# Defence Infrastructure Organisation

## **National Infrastructure Planning: Sheringham and Dudgeon Extension Projects**

I write in response to the Examining Authority's first written questions issued 27 January 2023.

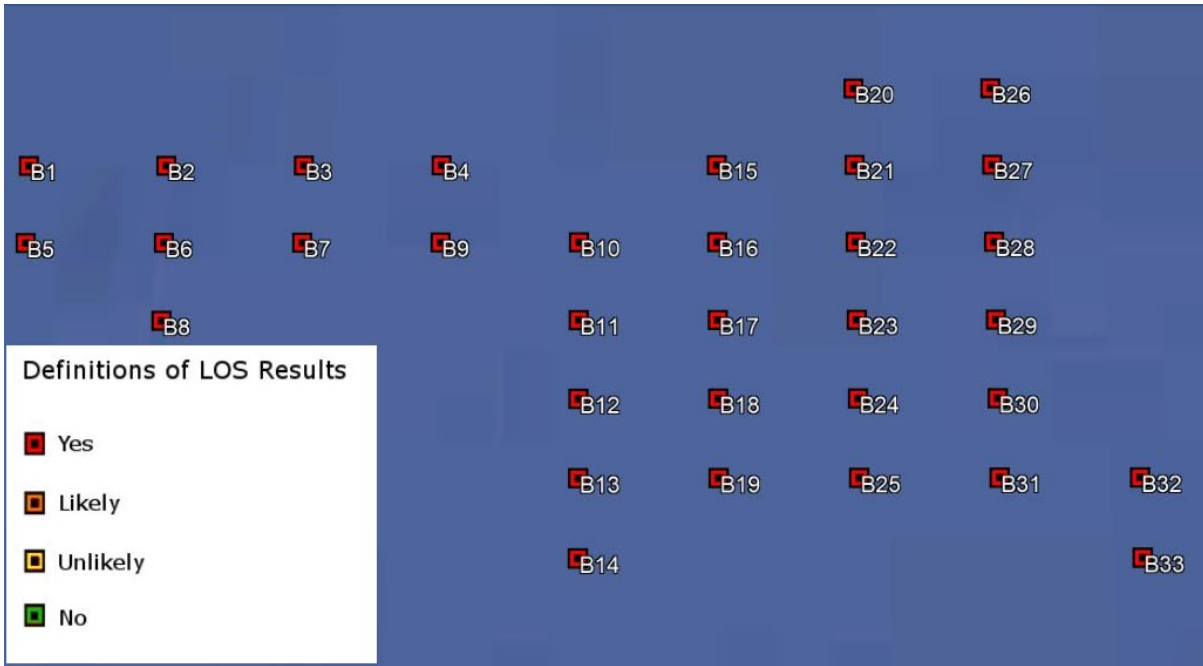
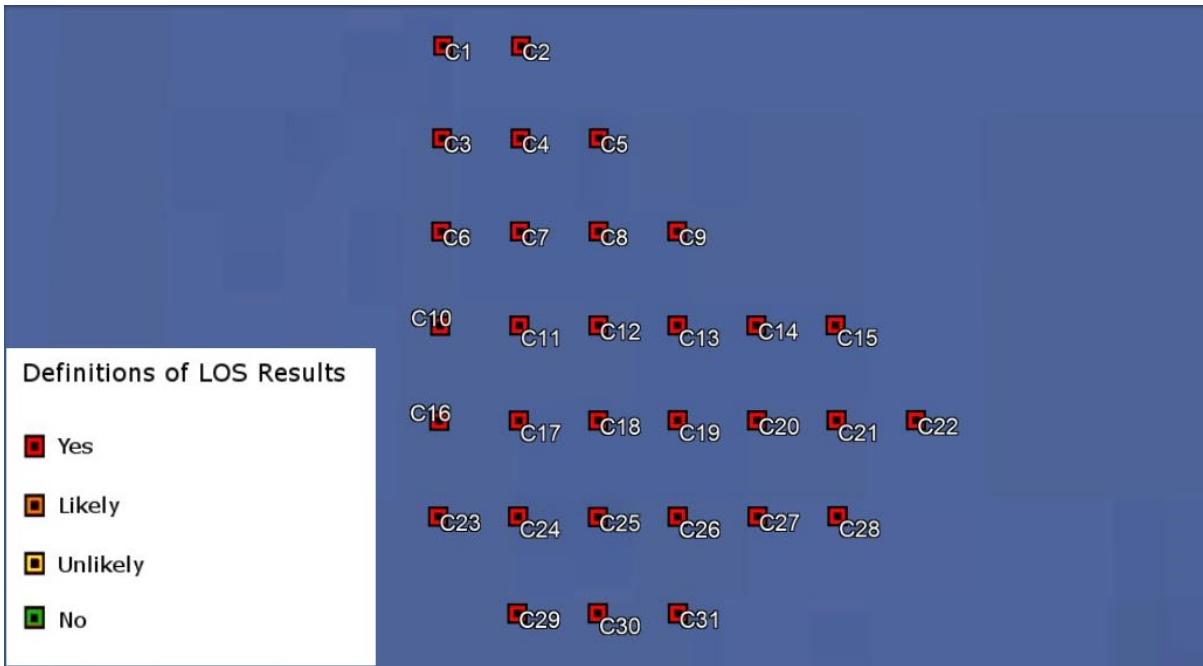
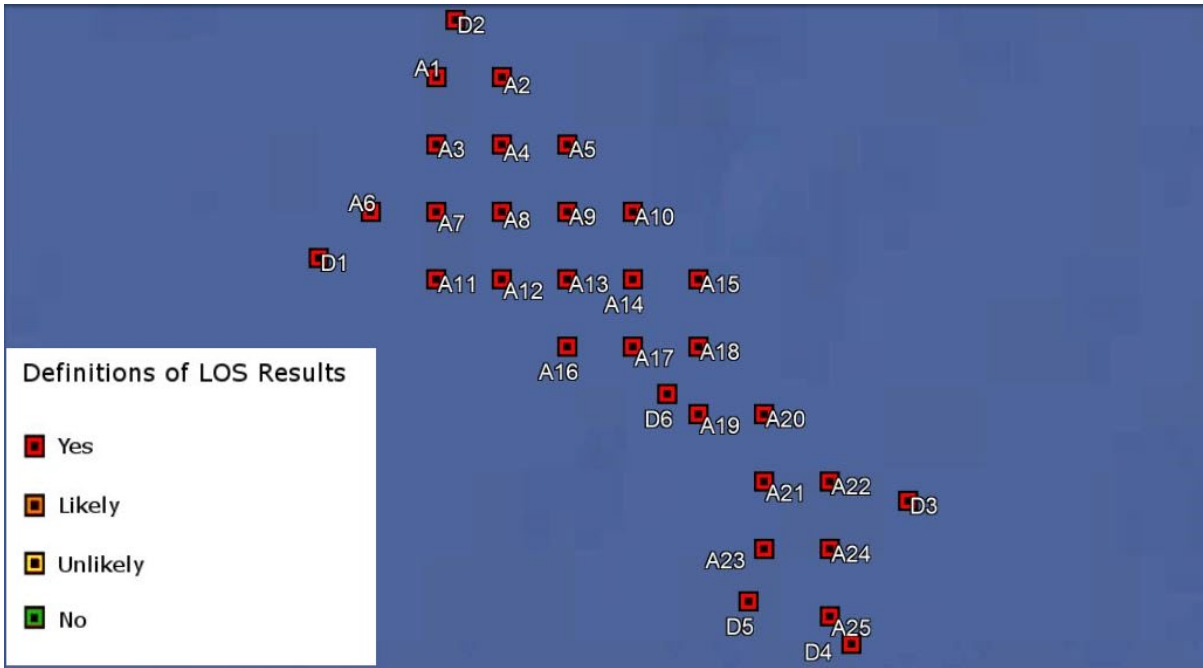
At this time the objection on the grounds that the development would have a significant and detrimental impact on the effective operation and capability of air defence radars deployed at Remote Radar Head (RRH) Trimingham and RRH Neatishead is maintained.

A meeting was held on 31 January 2023 to discuss the content of the representations submitted to the Examining Authority dated 19 January 2023. The steps/actions necessary to address MOD concerns have been identified. The MOD requires that the developer submits an acceptable Air Defence radar mitigation proposal for MOD assessment.
